**RE: View House Apartments
540 Paisano Ct. NE
Grading and Drainage Plan
Engineer's Stamp Date: 1/17/22
Hydrology File: D17D074**

Based upon the information provided in your submittal received 1/4/2022, the Grading & Drainage Plan is **not** approved for Building Permit. The following comments need to be addressed for approval of the above referenced project:

C-100

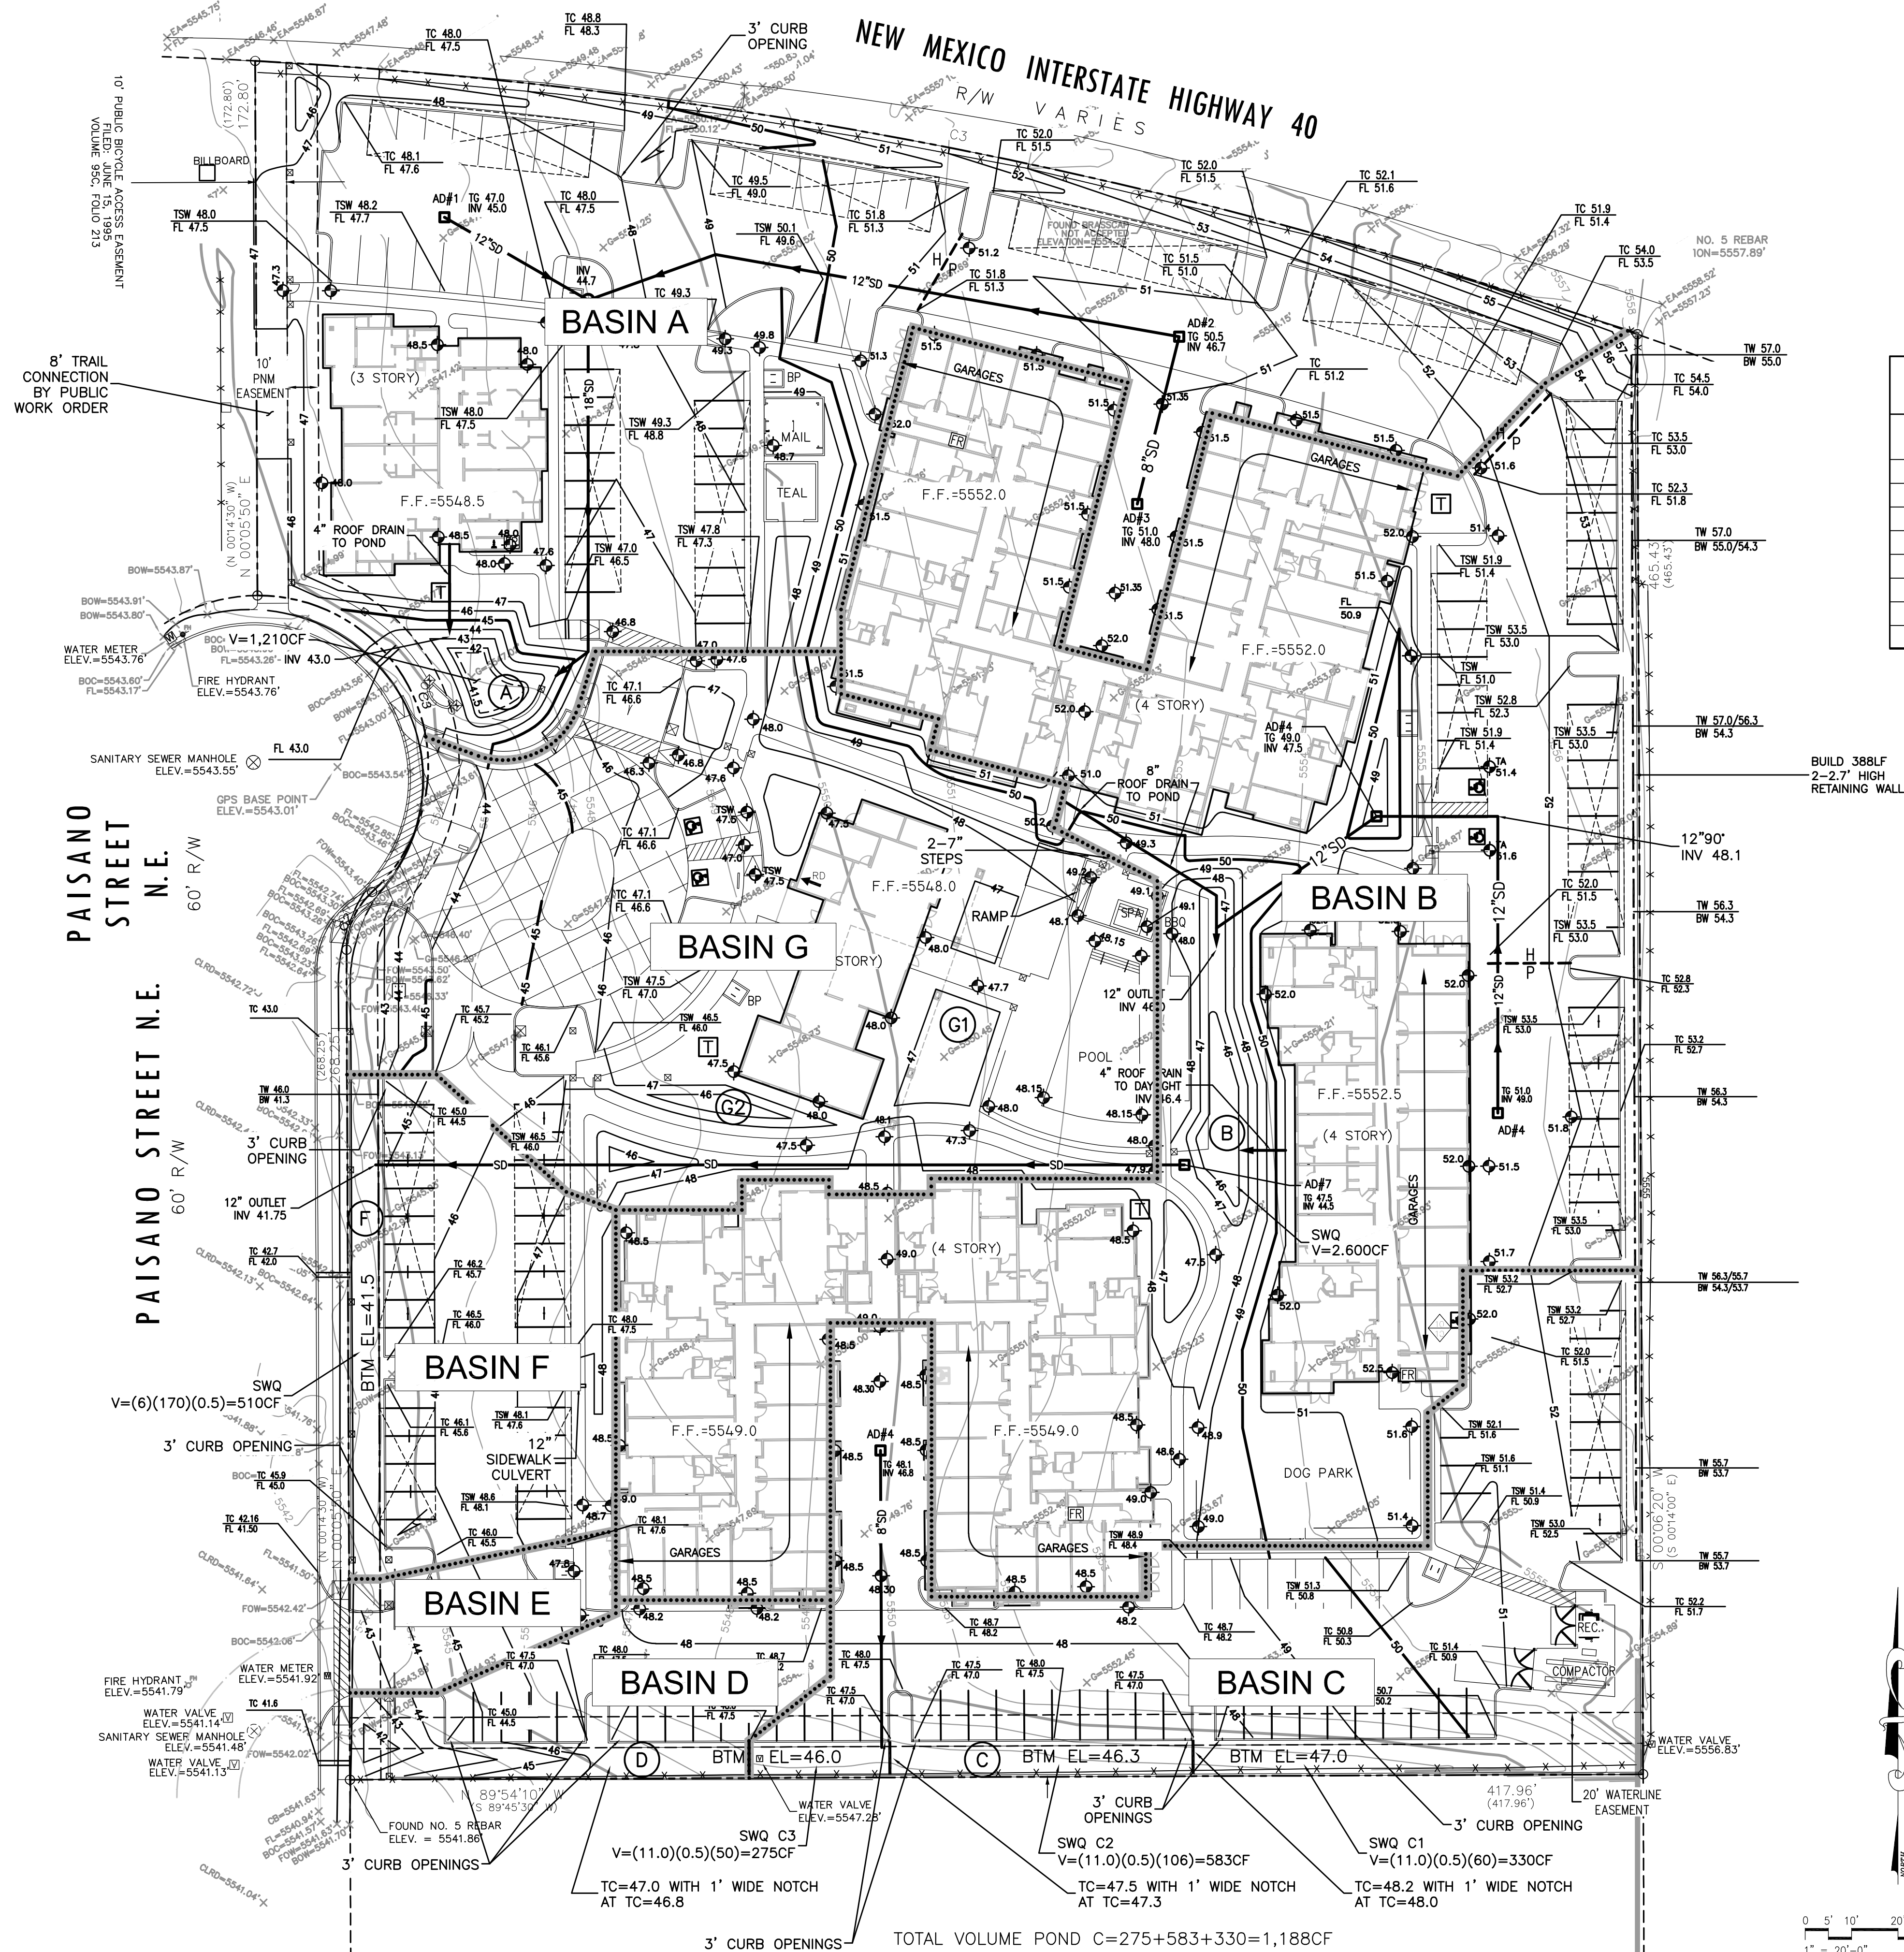
1. Please provide survey points.
2. Please provide an overall sheet.
 - a. Include a basin map.
3. A section/detail is required for each pond. Please label each one (e.g. pond a, pond b etc...)

6. Please include weir calculations for curb openings.
7. Please include SO-19 notes. (see attached in email)
8. Please label high points and as mentioned above delineate the basins.

CG-100

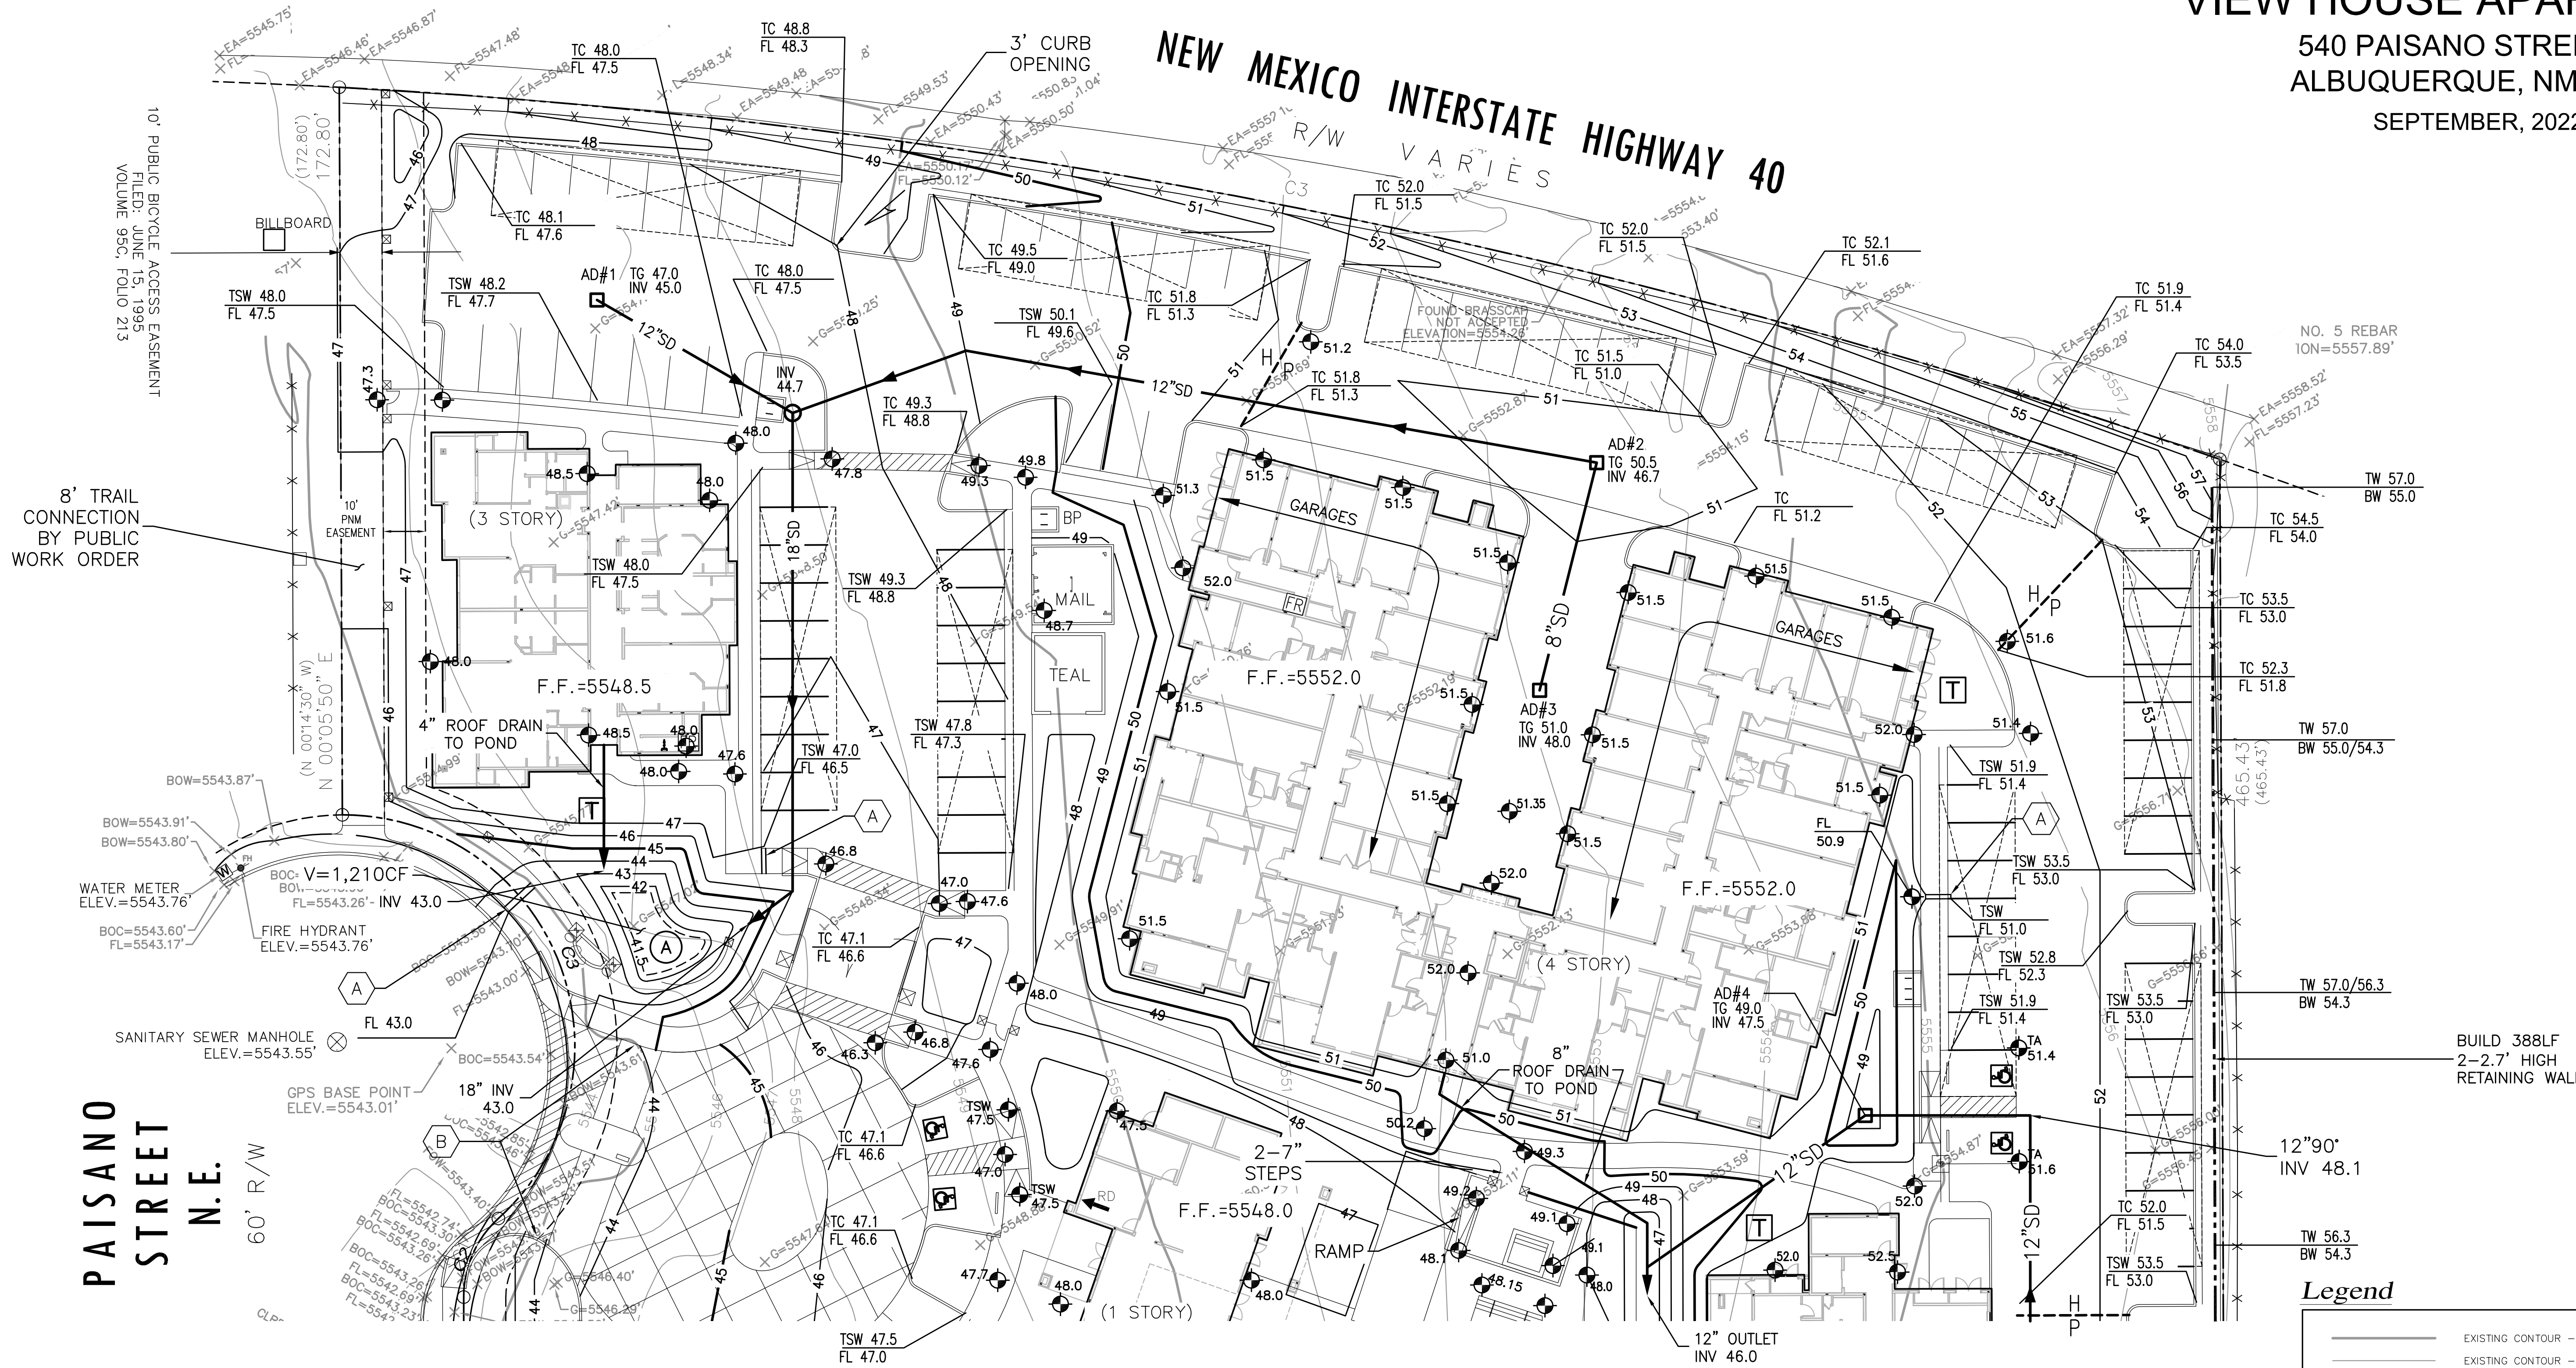
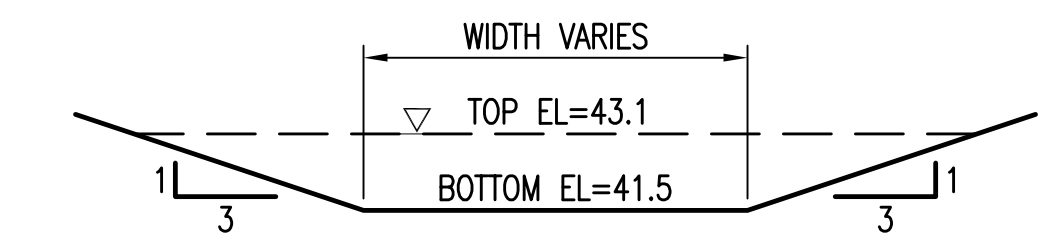
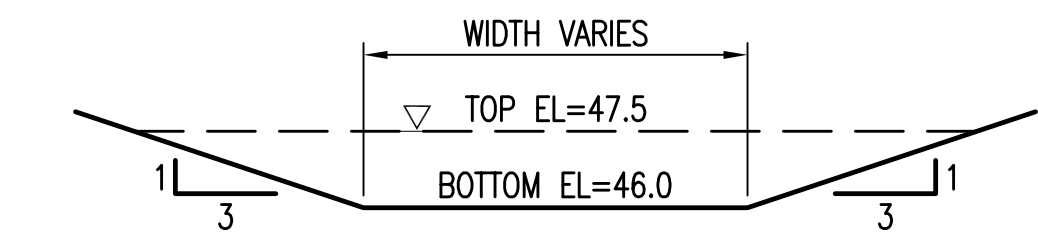
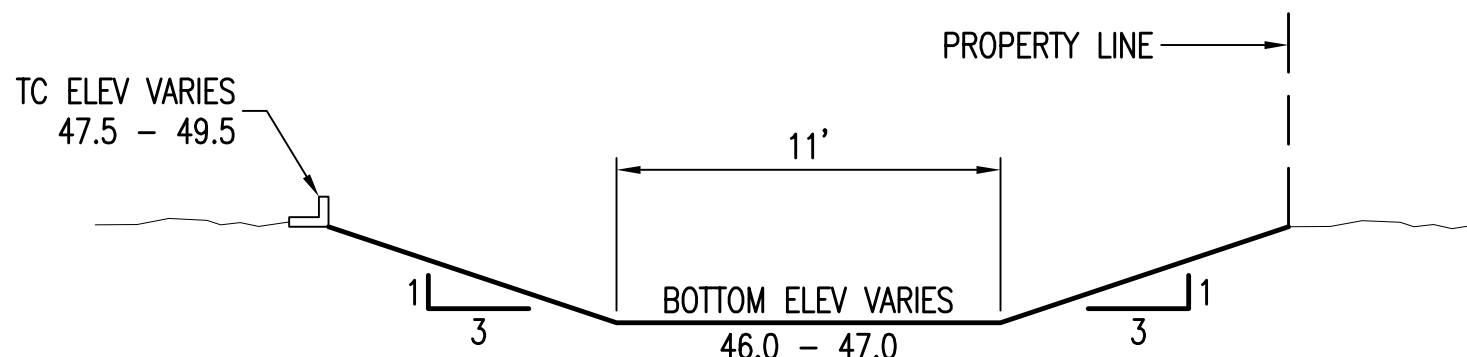
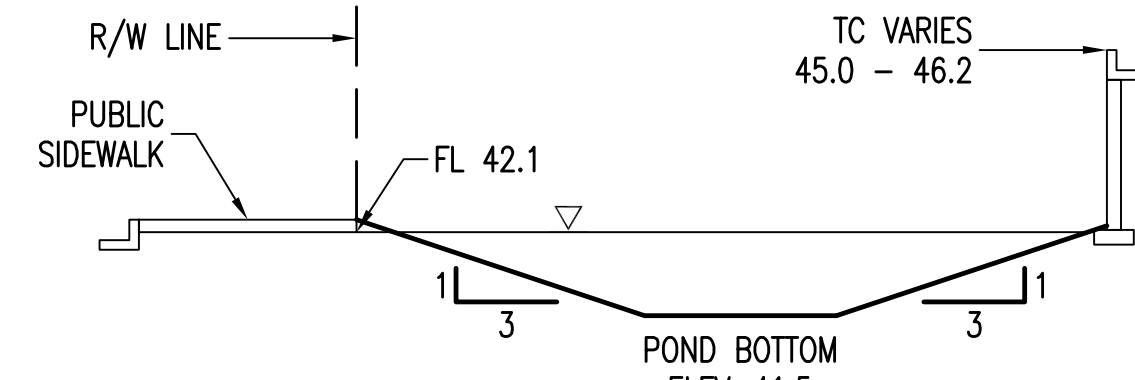
- a. These should also include volumes and clearly show how flow is getting to them.
 - b. The function of the SWQV pond should be kept in mind and please note the outlet of the pond above that elevation for each. Please note this for each section.

4. Please include all necessary background calculations used to determine resulting flows for existing and proposed.
5. Some of language is cut off on the bottom of the sheet CG-100.
